# WRITTEN RESPONSE TO EDF CONSULTATION ON FURTHER PROJECT CHANGES - JULY 2021

DEVELOPMENT CONSENT ORDER EN010012 : THE SIZEWELL C  
PROJECT

## PROPOSED CHANGE 16 : i and ii - BRIDLEWAY 19 LEISTON cum SIZEWELL

DRAWING TITLE:
 MAIN DEVELOPMENT SITE AND RAIL
 RIGHTS OF WAY PLANS - SHEET 2 OF 28

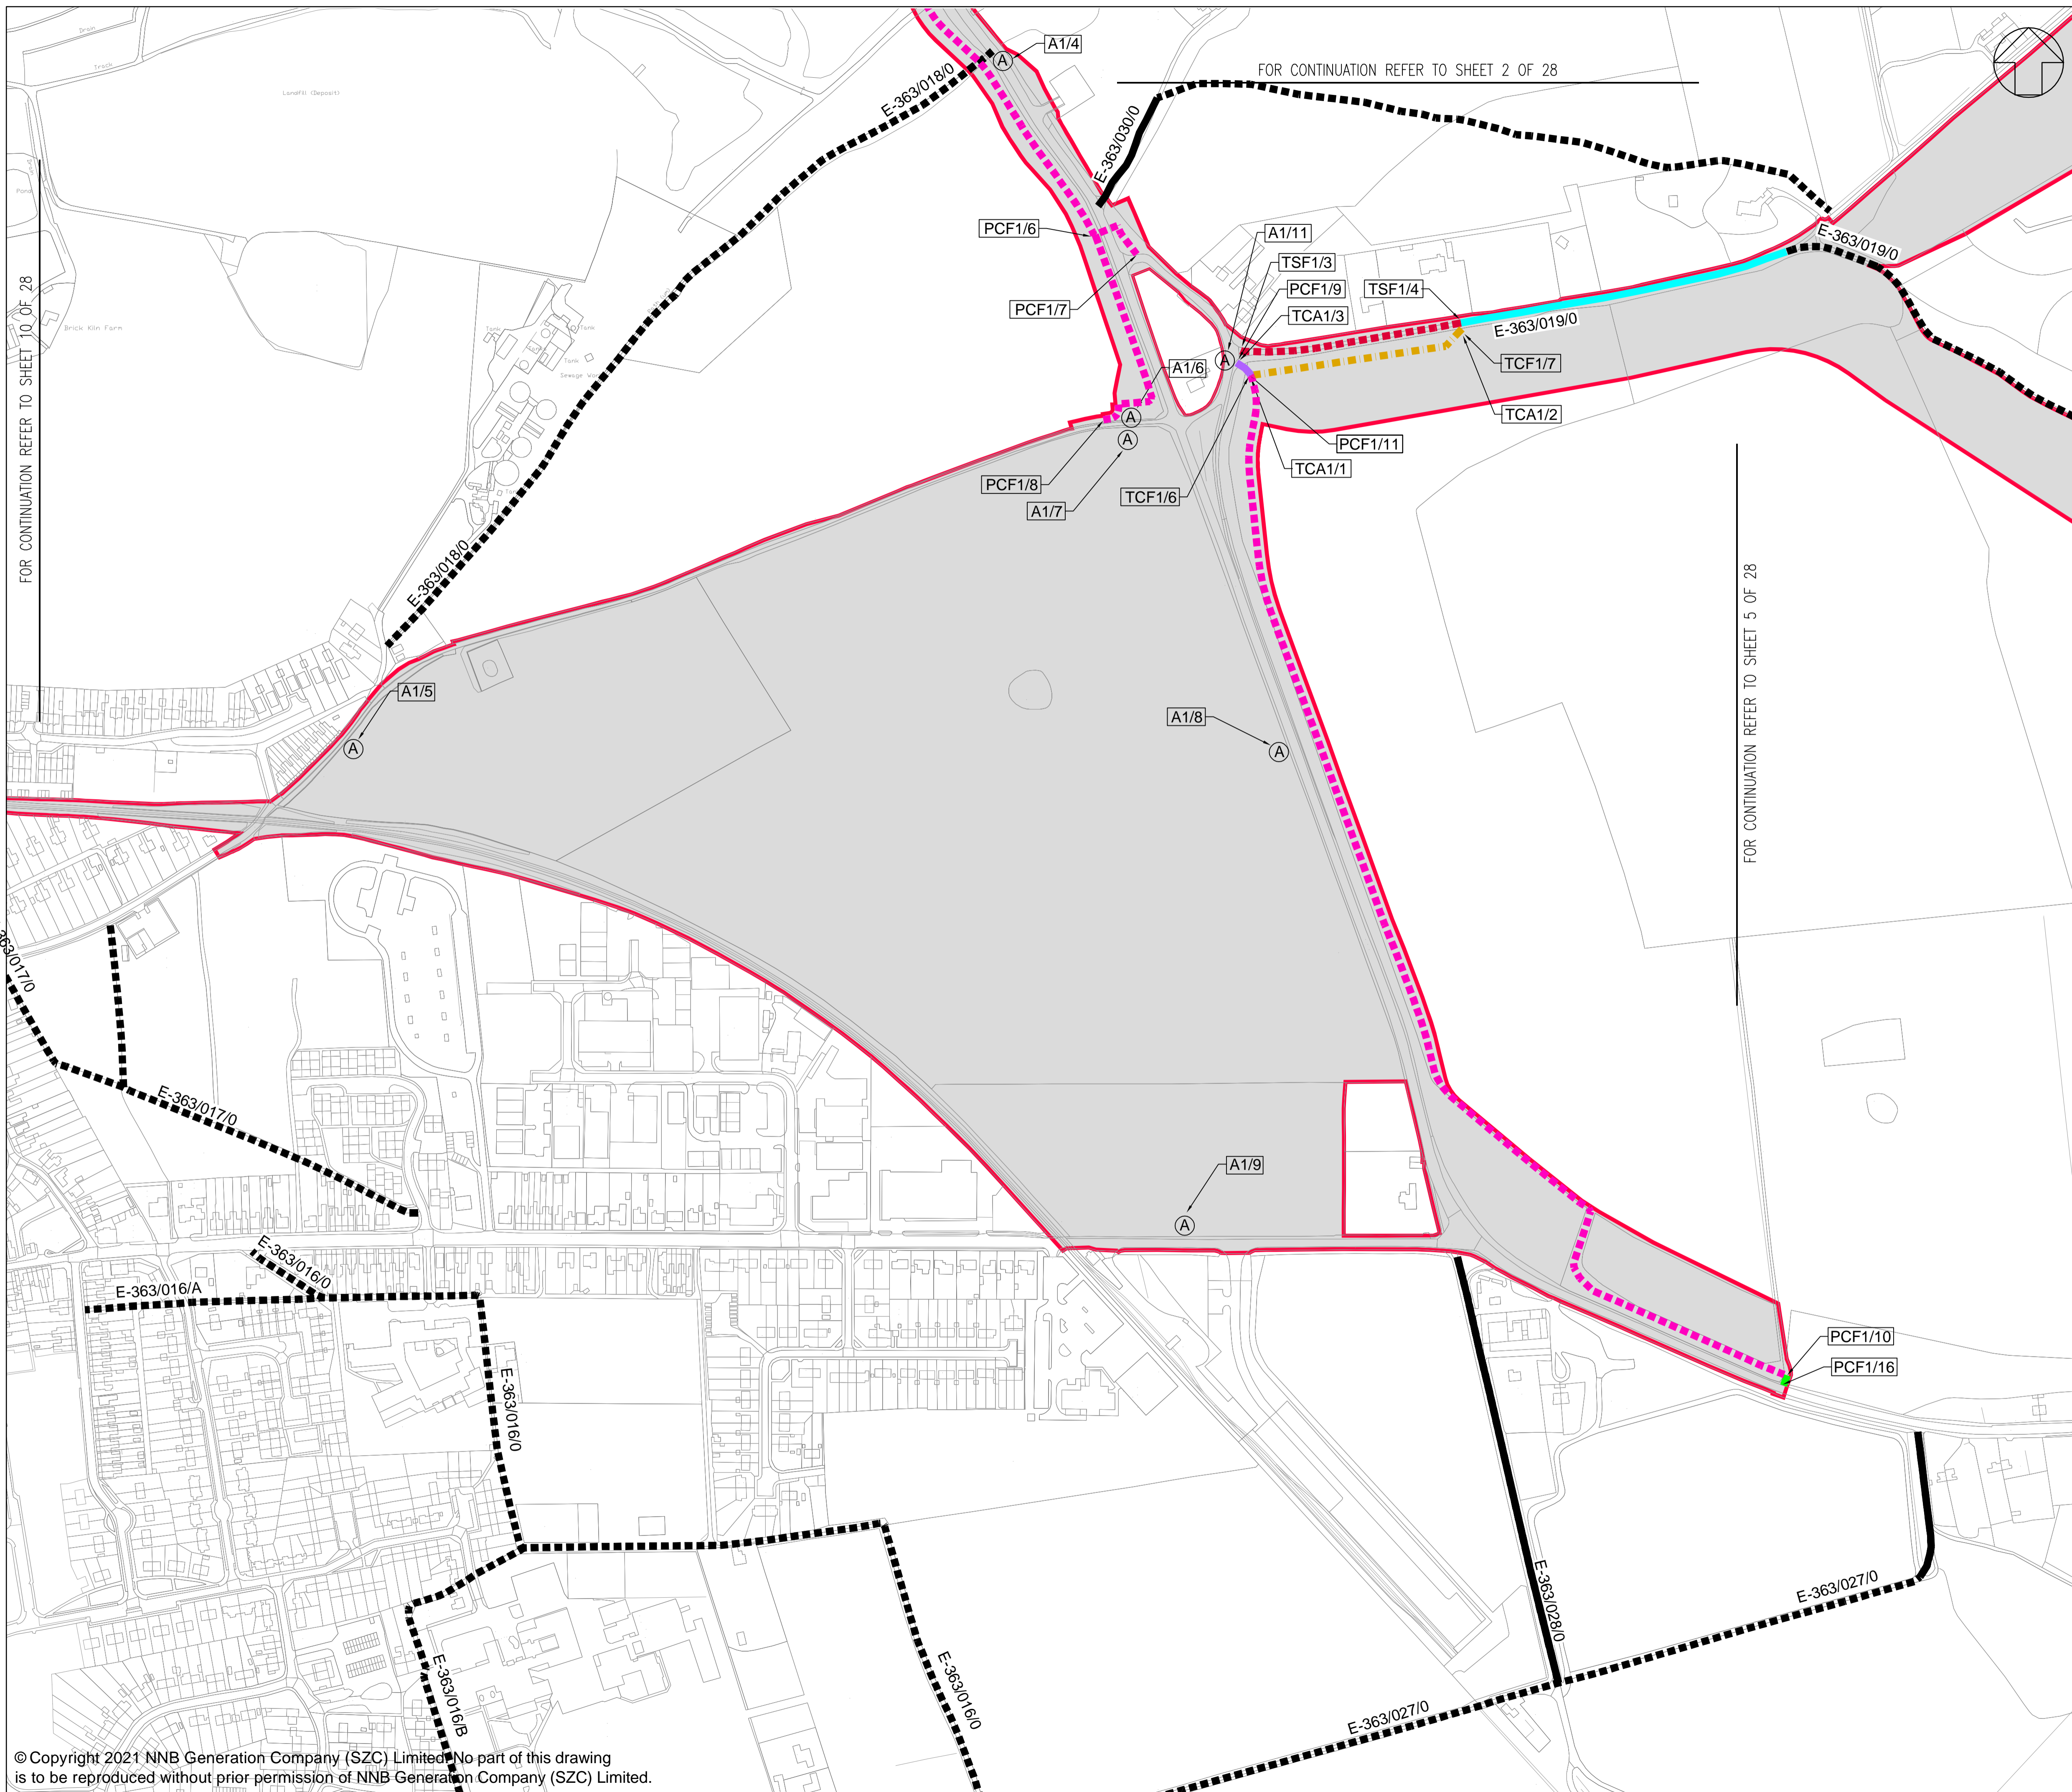
With reference to the northern section of **BR19** from the Eastbridge Road to the Kenton Hills car park , as shown on [AS 013: Rights Of Way Plans – Sheet 2 of 27](#), the northern section of **BR19** is described in the Key as '*to be reinstated*'. Nowhere in the other submission documents is there any evidence or proposals for the reinstatement of this public right of way, or that the current alignment will be protected during the proposed construction stage. **Community Pledge 6** describes the area as being returned to '*a standard befitting an AONB*' but this is too vague to be of any help or reassurance. **Community Pledge 7** does not mention the restoration of **Bridleway 19** either.
